Re: PR - 2025 - 020054 PA - 2025 - 00019 1927 Arno St. SE

Mr. Najera and I are in pursuit of gaining Minor-Final Plat approval for our property referenced above, and we would like to address your comments from Sketch Plat review:

LOT 14-A in BLOCK 1

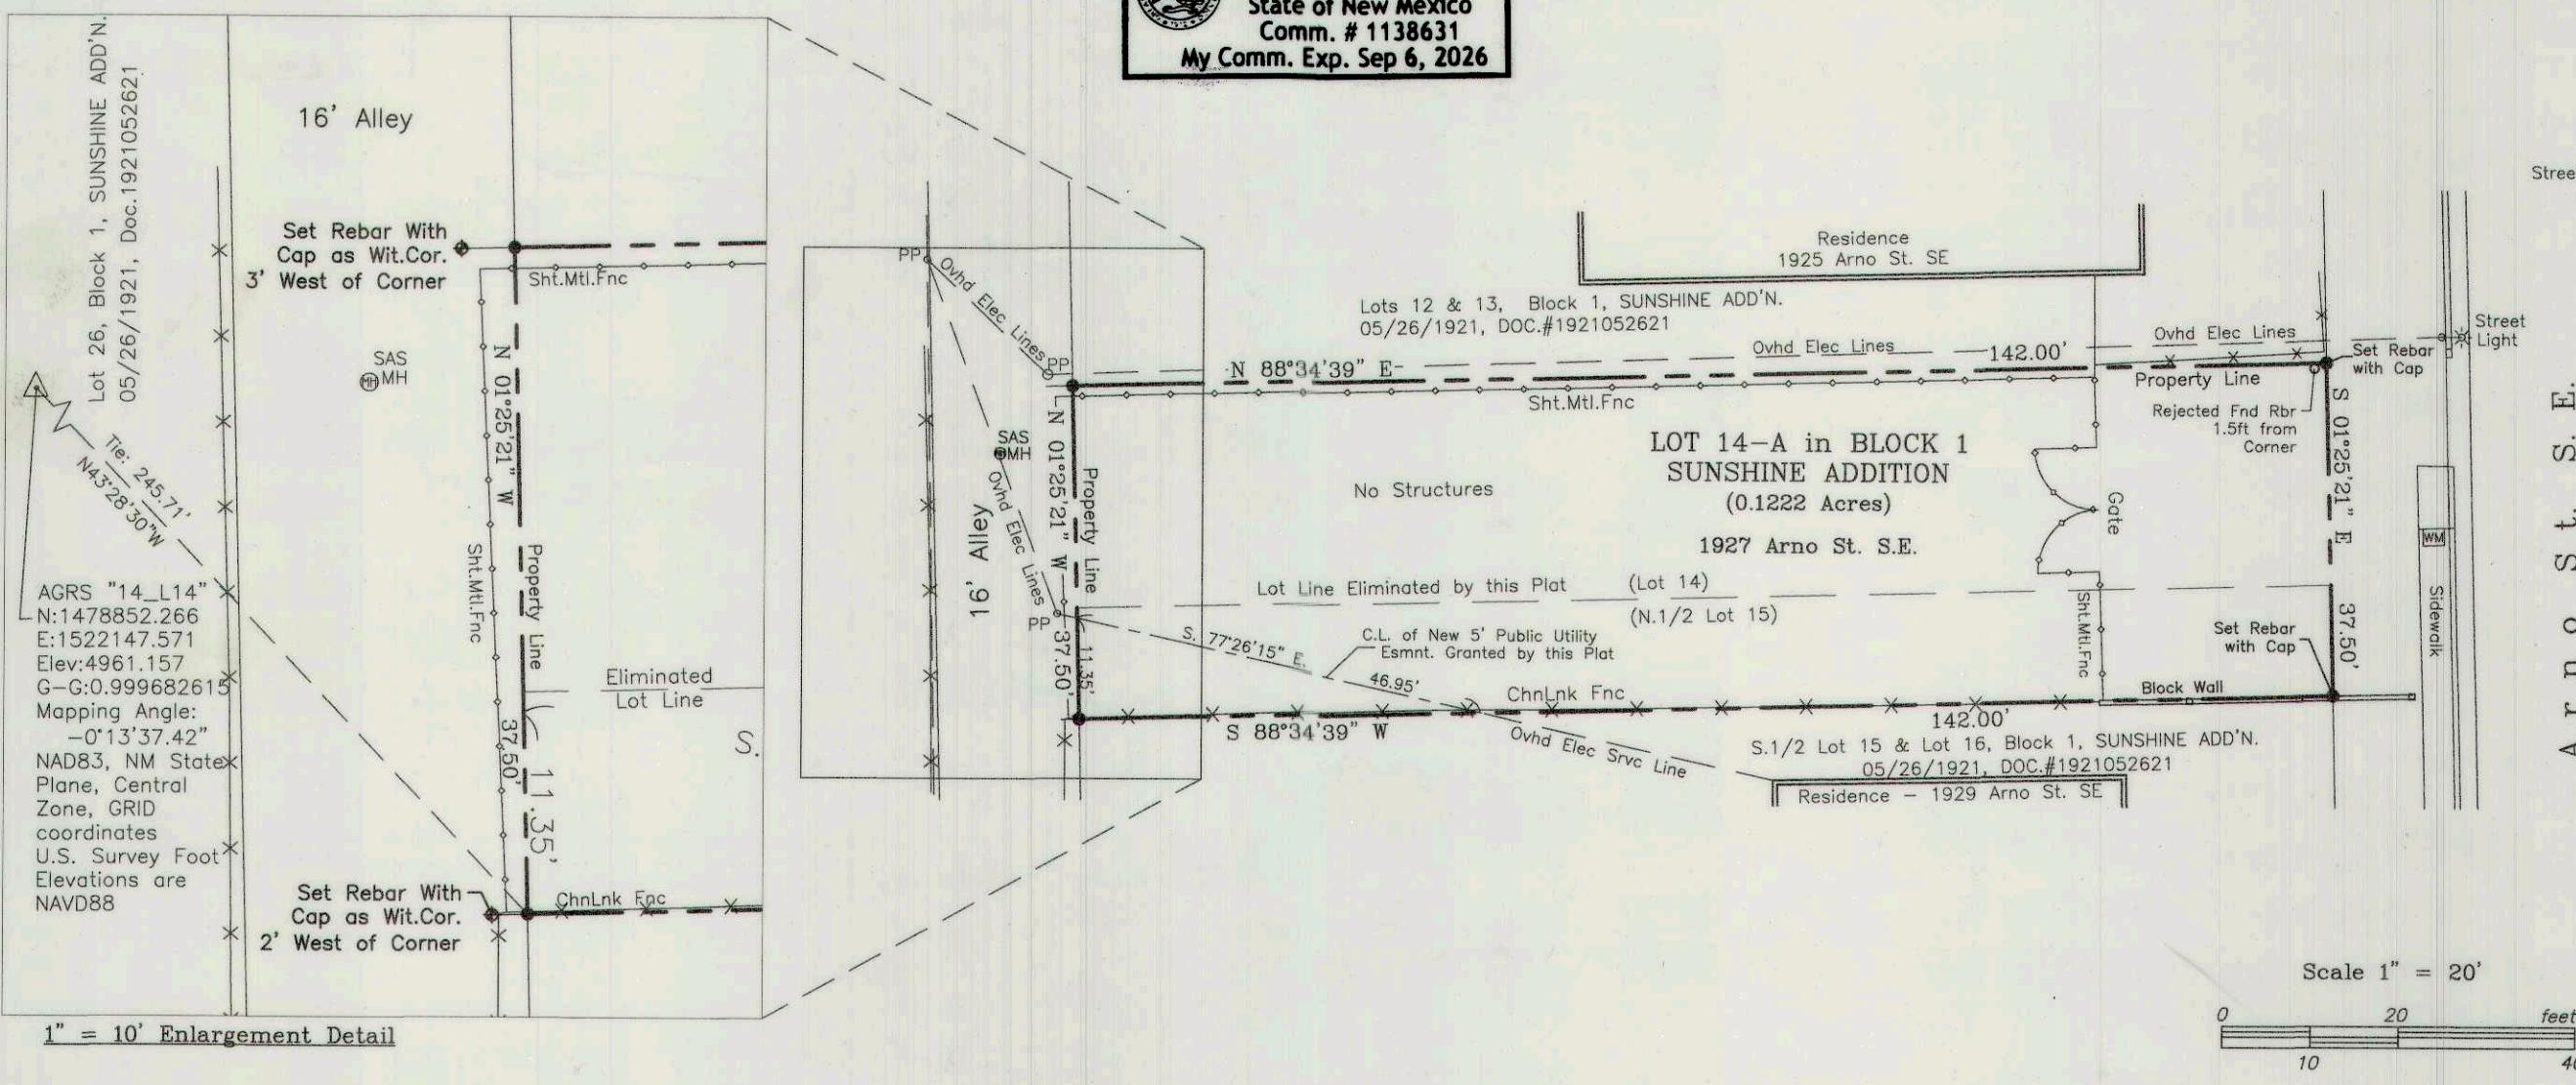
Regarding sidewalks: Arno is a fully developed residential street that is a low speed local with existing 3.5' sidewalks. Most properties along here have walls or fences at the back of the existing sidewalk and would make widening of the sidewalk throughout the neighborhood difficult. We are asking for a determination to allow the existing sidewalk to remain 3.5'.

Regarding the rear alley: The existing 16' alley is bounded on both sides with existing power poles, walls and fences that cannot be easily or economically moved to widen this alley. We are asking for a determination to allow the alley to remain at 16'.
